**KIRKLEES METROPOLITAN COUNCIL  
INVESTMENT & REGENERATION SERVICE**

**DELEGATED DECISION TO DETERMINE PLANNING APPLICATIONS**

Reference No:	<b>2025/62/92850/W</b>
Site Address:	Holmleigh, 33, Southgate, Honley, Holmfirth, HD9 6NT
Description:	Demolition of existing brick porch and flat roof garage and erection of lean-to porch, detached gable roof garage and external alterations (within a Conservation Area)
Recommending Officer:	Molly Storer

## **Officer Report**

Proposed North East Elevation - 1:100

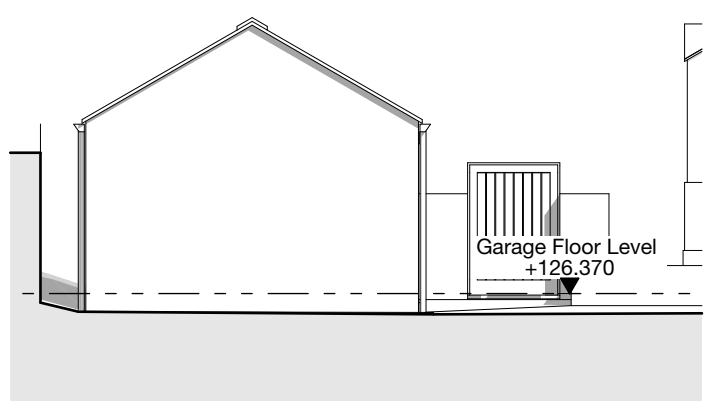
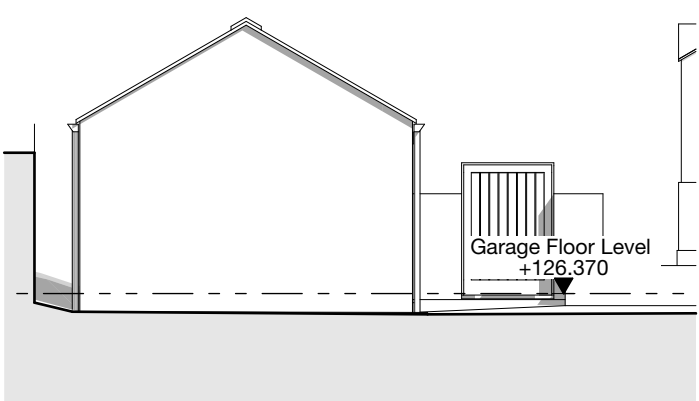
Following discussions with KC Conservation and Design the agent was contacted to seek amendments to incorporate bigger sheets of glass rather than small panes to the northeast elevation (where external alterations create

KC Conservation & Design (Informal) – Bigger sheets of glass should be incorporated rather than small panes to the northeast elevation (where external alterations create access to the rear garden) to keep with the character of the original windows.

access to the rear garden) to keep with the character of the original windows. The agent responded with amended plans to show this.

Following discussions with KC Conservation and Design the agent was contacted to seek amendments that would incorporate bigger sheets of glass rather than small panes to the northeast elevation (where external alterations create access to the rear garden) to keep with the character of the original windows. The agent responded with amended plans to illustrate this. The amended plans are considered to comply with heritage policy and are an improvement to that originally submitted.
